From: Alistair Dodd [REDACTED]
Sent: 04 May 2017 17:11
To: Anita Gardner
Cc: Juan Baeza; [REDACTED]
Subject: RE: A/64/17/DOC 1-6 The Cottrells, Angmering

Thank you for the email and please find attached our amended drawing No ADC 962/03A.

I have received the attached consultation response from County Highways and would appreciate receipt of the additional information requested within the next 10 days or it is likely that discharge of condition 5 will be refused. In addition I am advised by local residents that notices have been displayed at the site advising that works will be commencing on Monday. I would remind you that the pre commencement conditions are still to be discharged and would urge you not to start work until details have been formally agreed in writing. I would appreciate your assurance that no development will take place prior to discharge or I will have no alternative other than to request that the matter is raised as a compliance case.

A		Flatbed delivery lorry added		04.05.17	
Rev		Description		Date	
Job Reference			Client		
New House The Cottrells Angmering			AM Homes Ltd		
Drawing Title			Drawing No		
Site Works Plan			AD962/03		
			Rev		
			A		
Date	Scale	Dwg Size	Plot Style	Drawn	Checked
28.02.17	1:100	A3	AD09xscale	TCG	AD

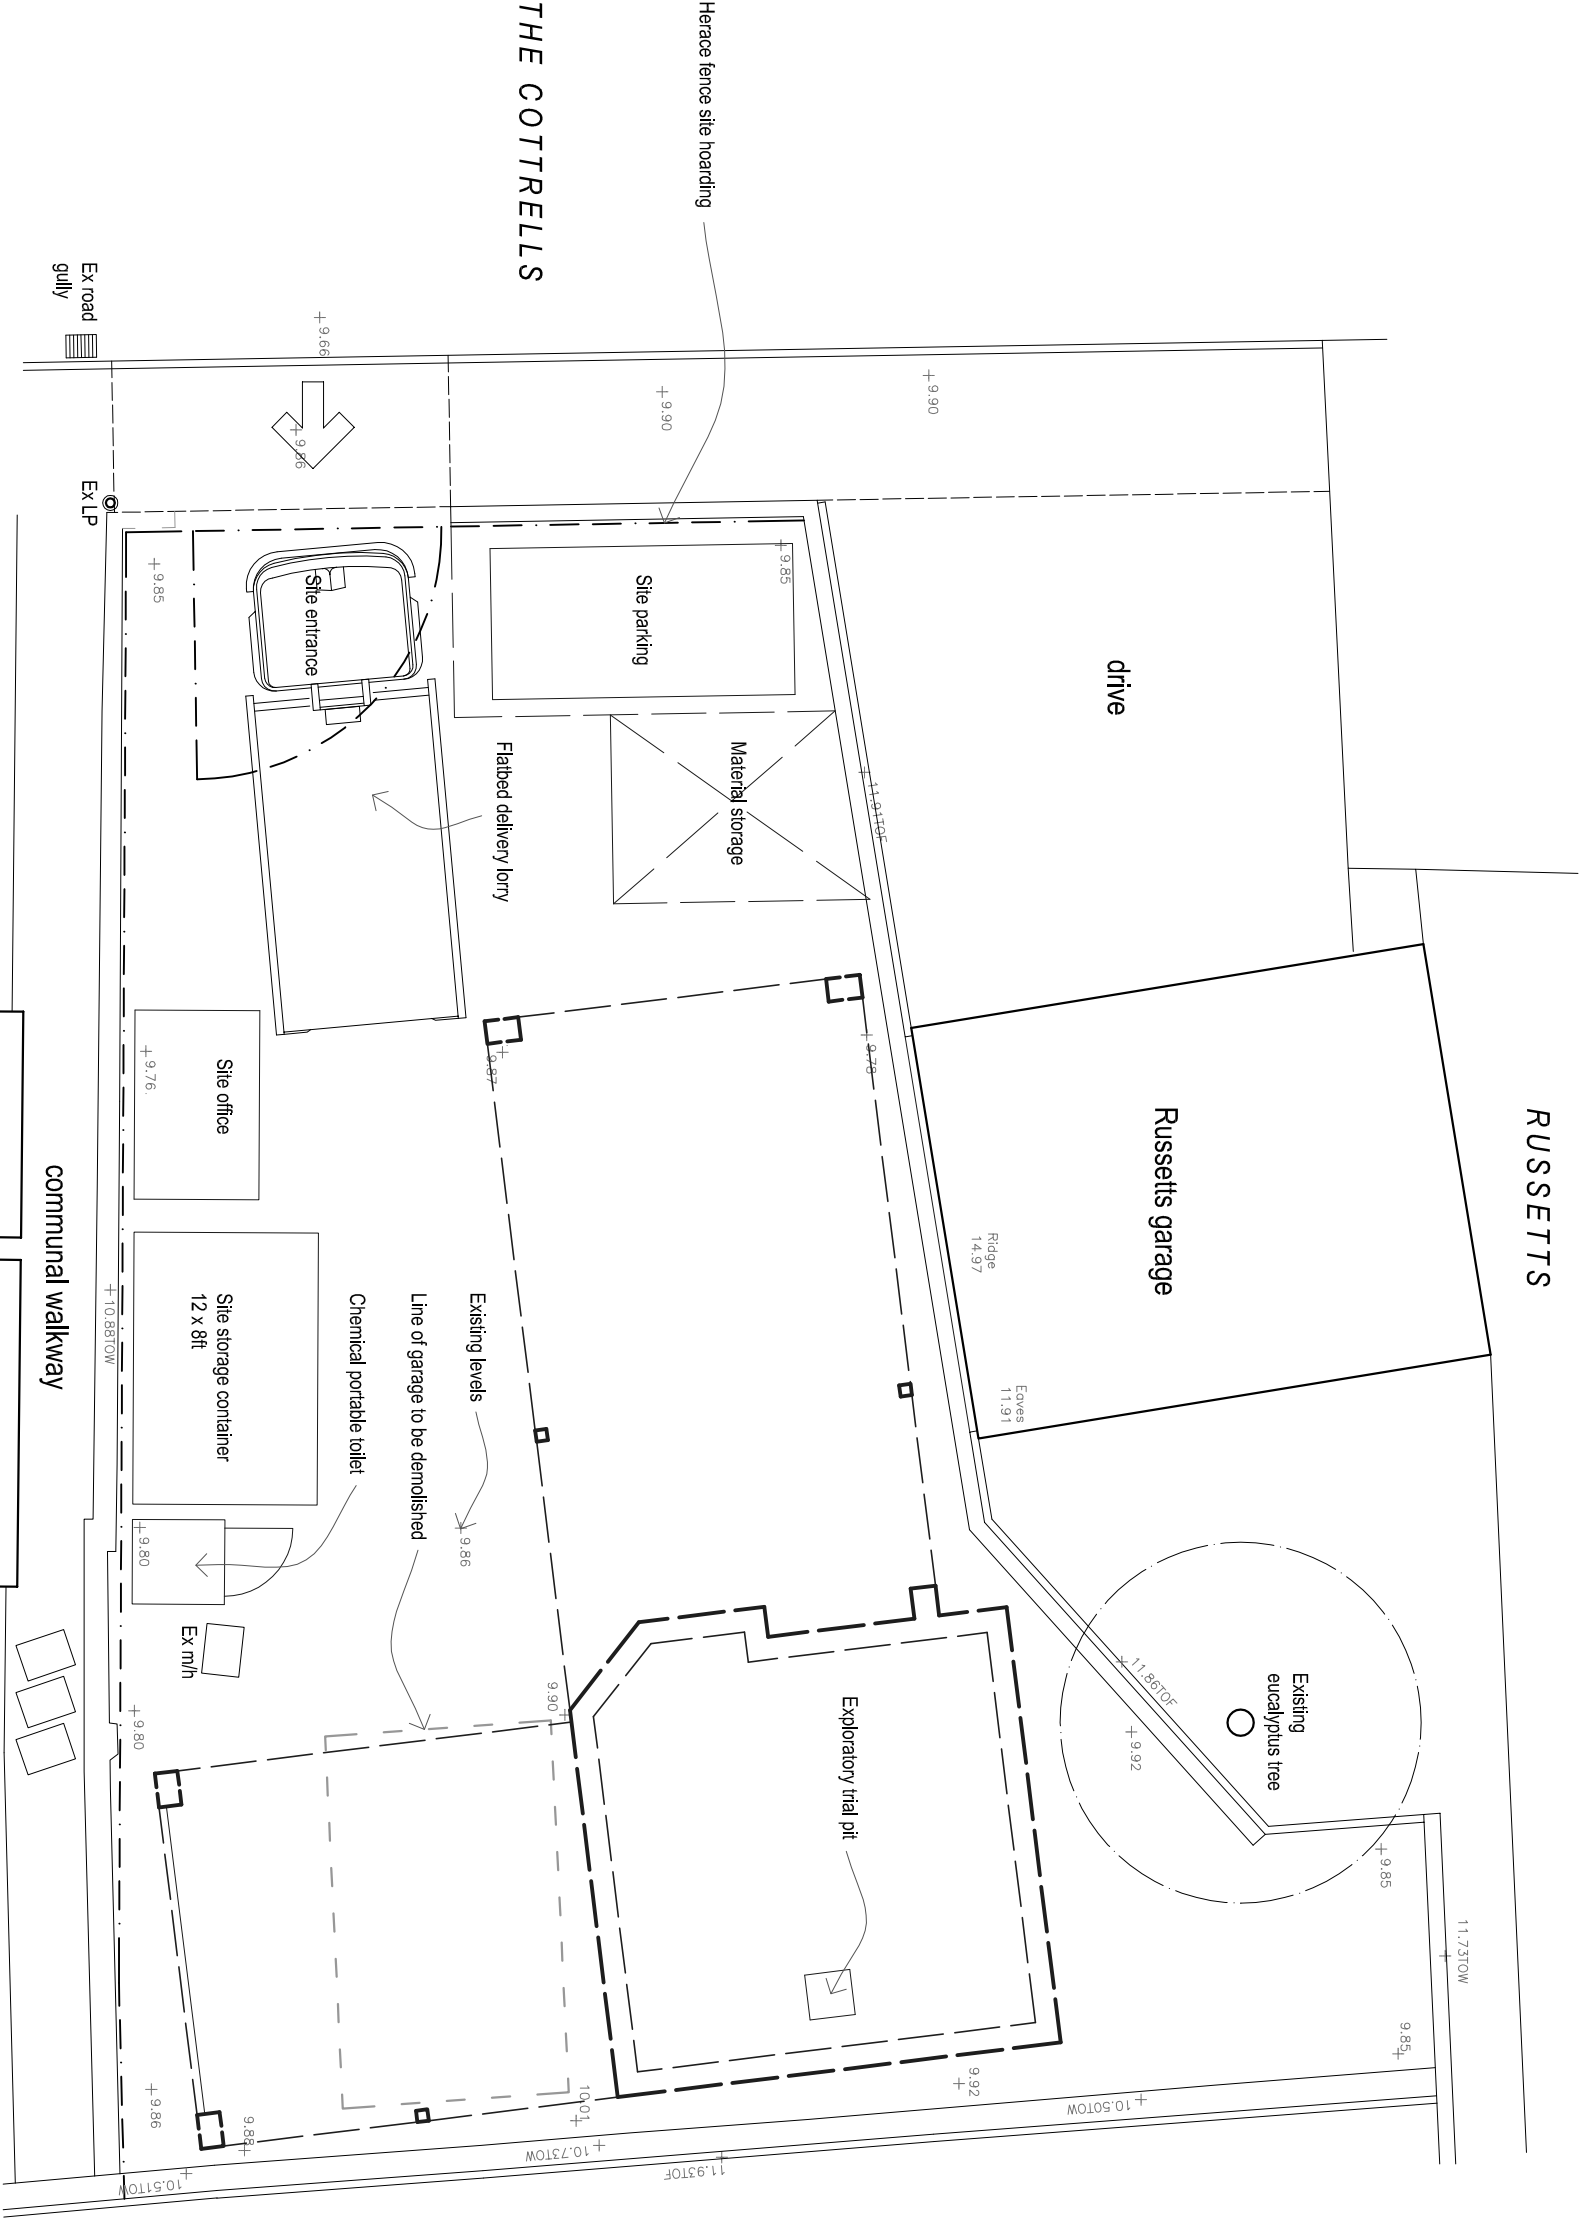
In response to the Highways query I confirm materials can only be delivery by small or medium sized vehicles due to the narrow site entrance into the Cottrells. As such we are able to accommodate such vehicles within the site area without blocking the cul-de-sac of the Cottrells.
